# CITY OF ALBUQUERQUE

**Re: Pacific Mutual Door and Window  
4601 Paseo Del Norte NE  
Request Permanent C.O. - Accepted  
Engineer's Stamp dated: 3-5-15 (C17D005)  
Certification dated: 6-22-15**

**RE: Pacific Mutual Door and Window - Tract 1, Lands of L.A.  
Paving, Grading & Drainage Plan  
Engineer's Stamp Date 3-5-15 (File: C17D005)**

CITY OF ALBUQUERQUE PUBLIC WORKS DEPARTMENT	
TITLE: PACIFIC MUTUAL DOOR & WINDOW PAVING & GRADING AND DRAINAGE PLAN	
DESIGN REVIEW COMMITTEE	CITY ENGINEER APPROVAL
LAST DESIGN UPDATE	MO./DAY/YR.
CITY PROJECT NO.	ZONE MAP NO. C-17-Z
SHEET 1 OF 1

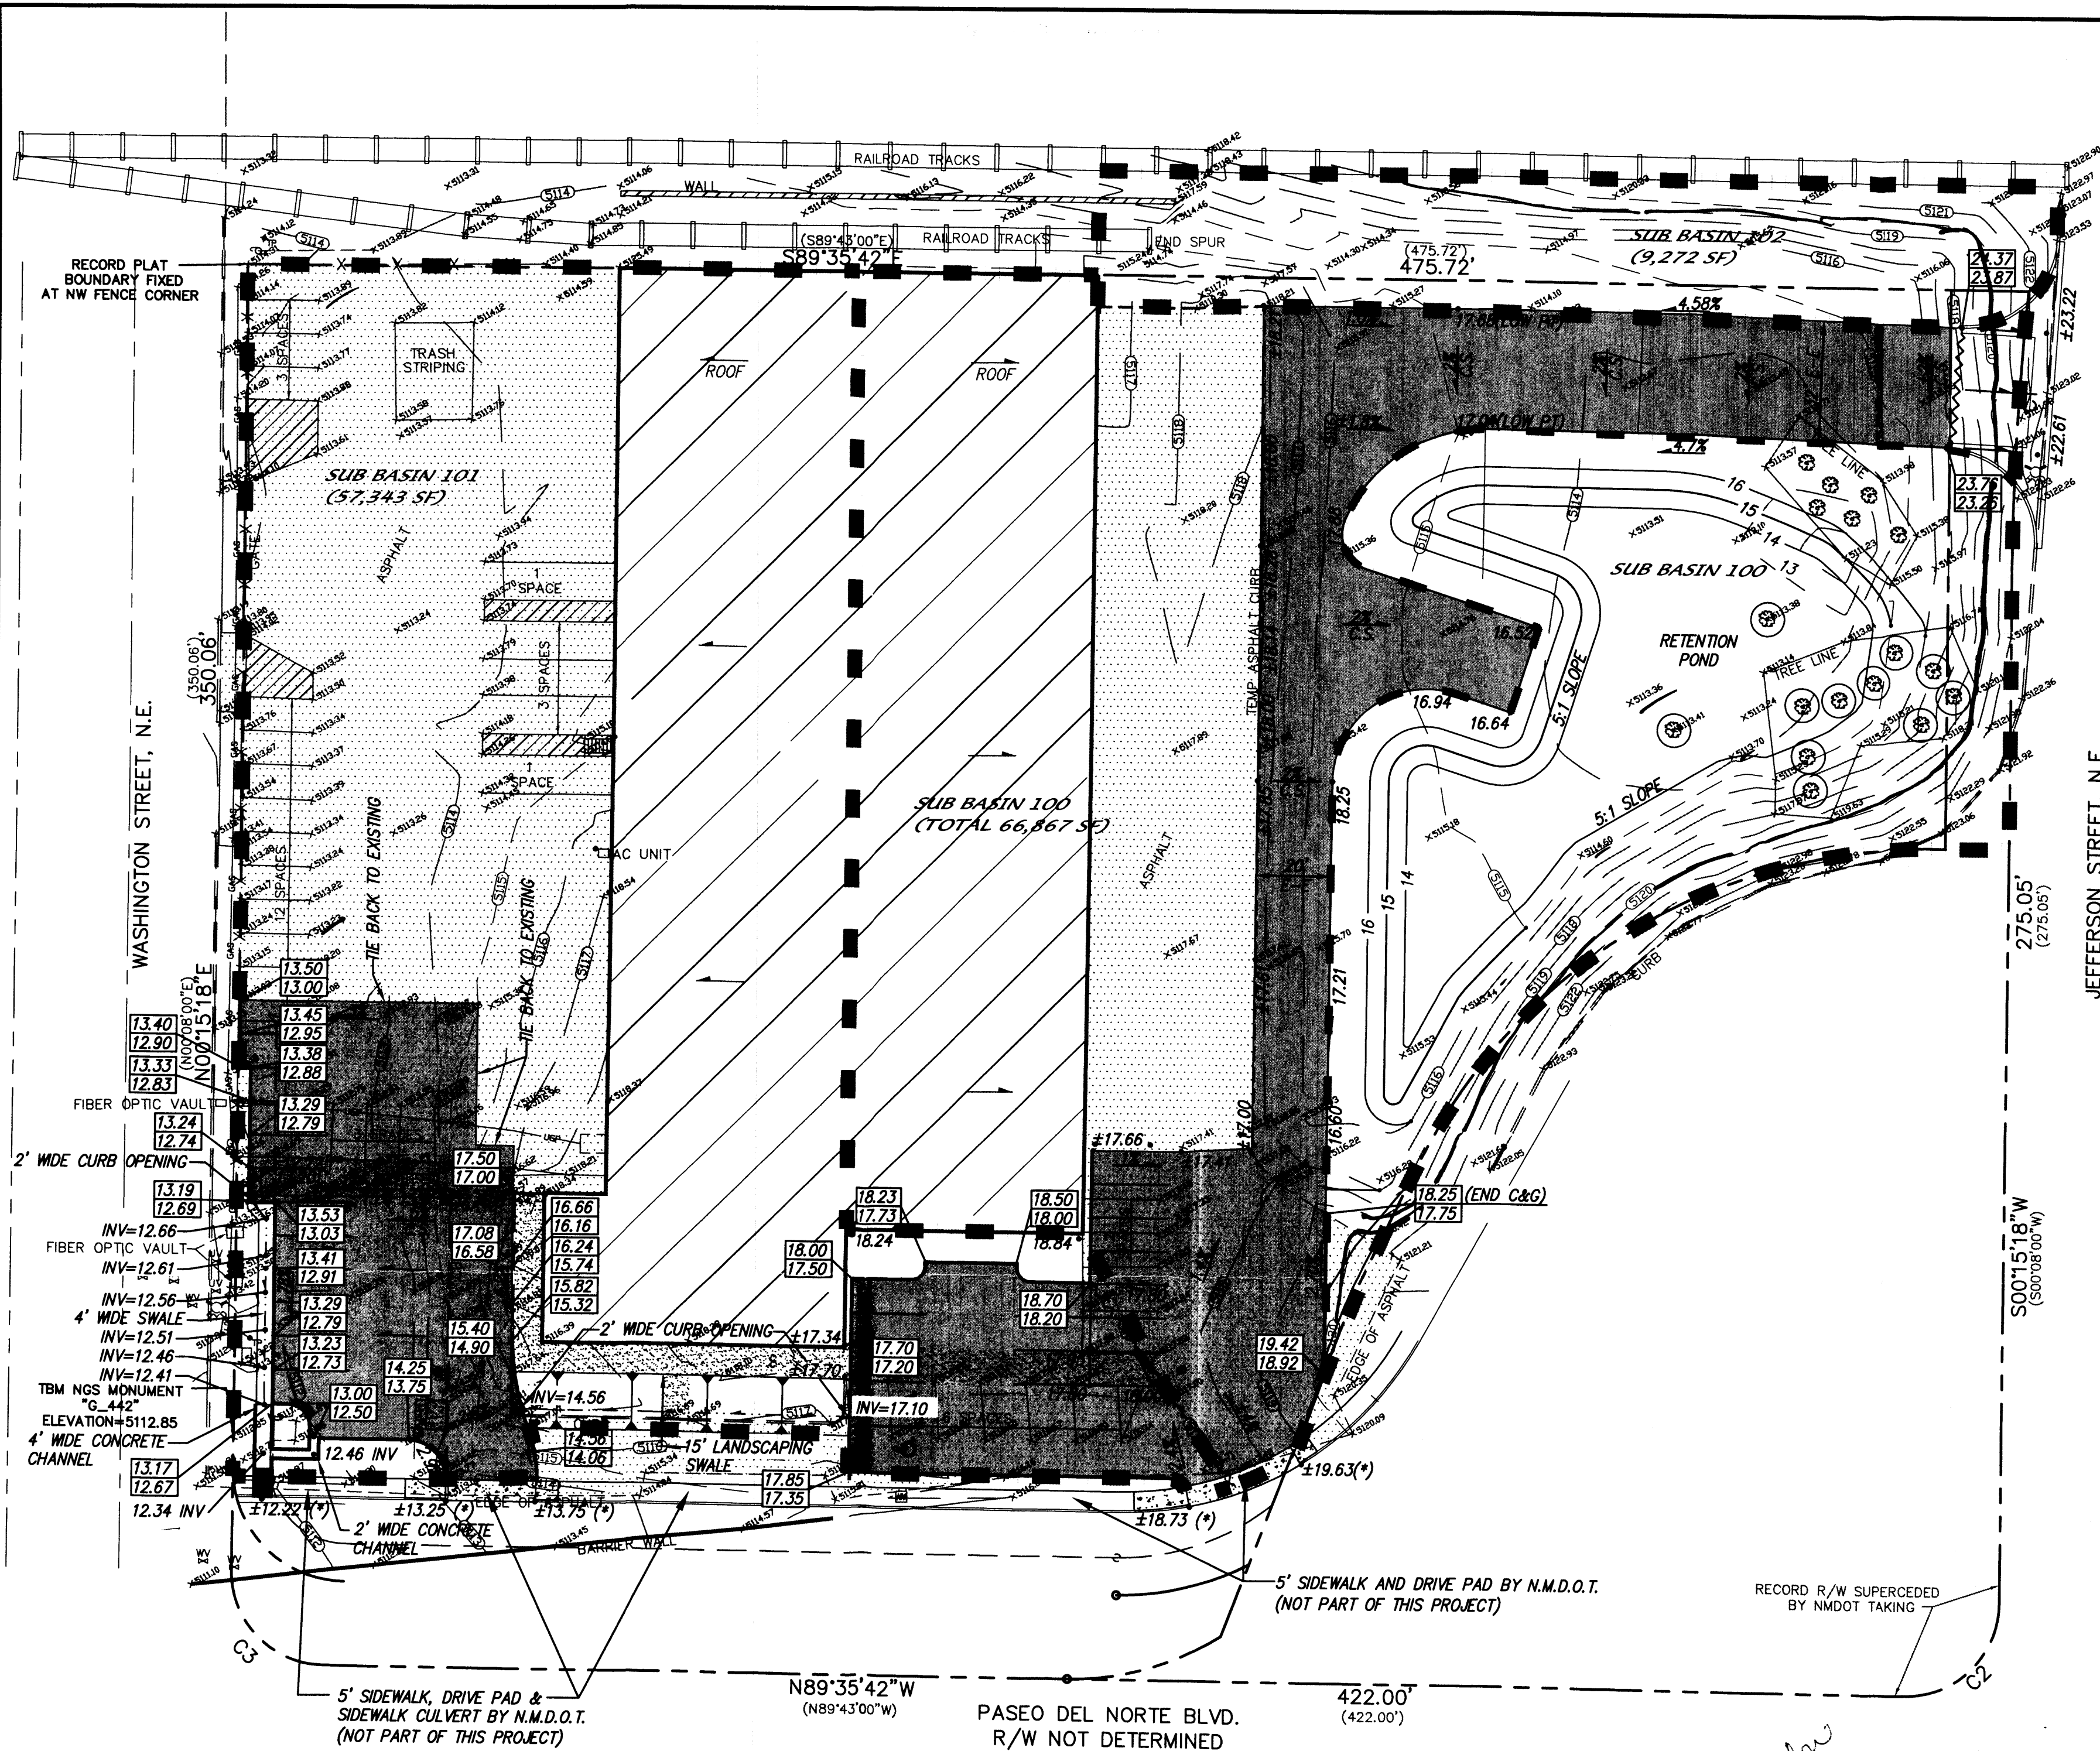
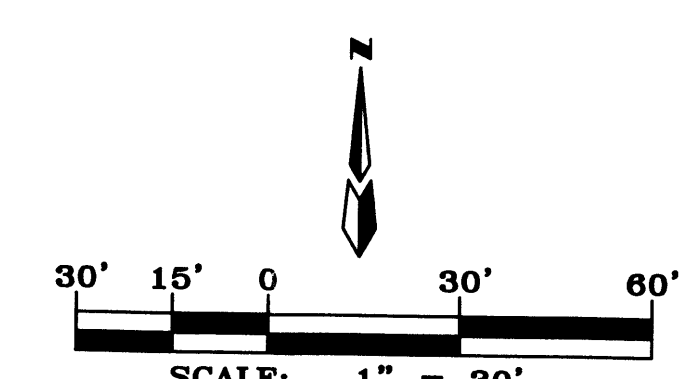
1. . Indicate the Emergency overflow path as discussed – ~~through the swale along the south side of property.~~

1. Indicate the Emergency overflow path as discussed – through the ~~swale~~ <sup>~~Swale~~</sup> along the ~~south~~ side of property.
